Application No: A/131/21/HH
Site Address: The Warren High Street Angmering BN16 4AE
Description of works: Erection of two storey side extension and single storey infill extension following the demolition of existing garage. This application may affect the character and appearance of the Angmering Conservation Area.

Thank you for your internet representation made on 15th July 2021 which has been recorded as no objection with the comments as follows:

PROPOSED ELEVATIONS

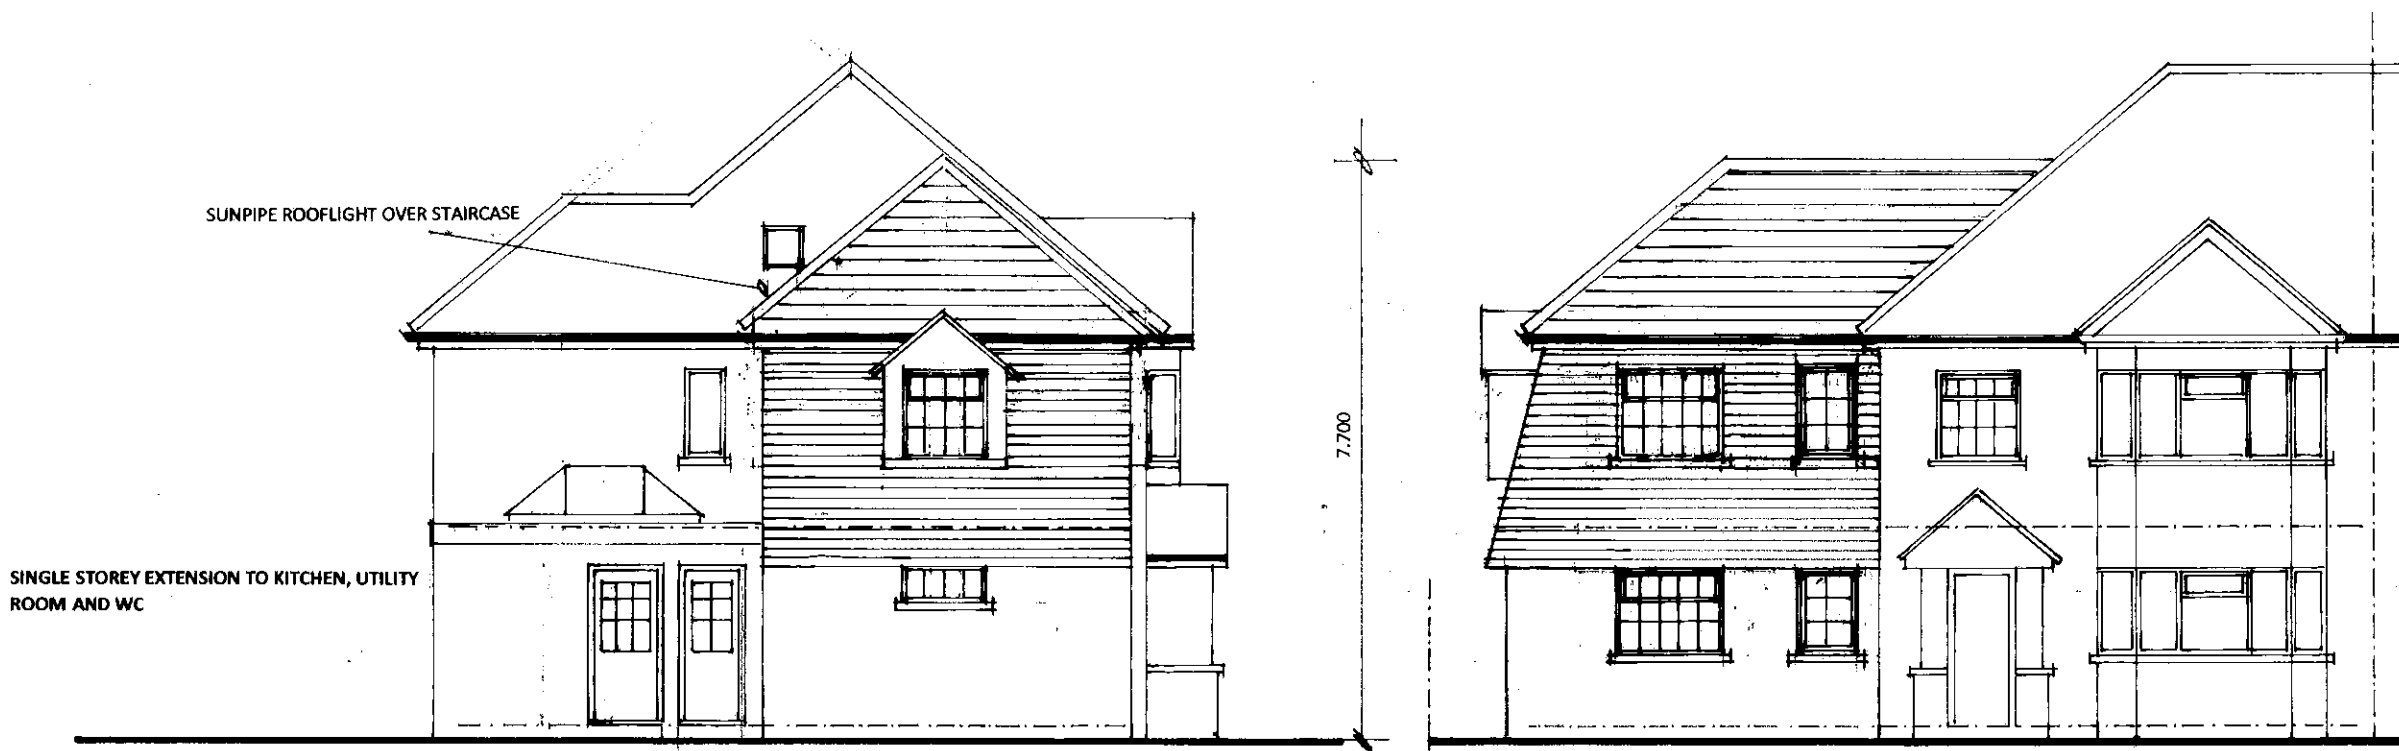
APC would ask the applicant to contact the Conservation Officer with regard to the design for the new windows.
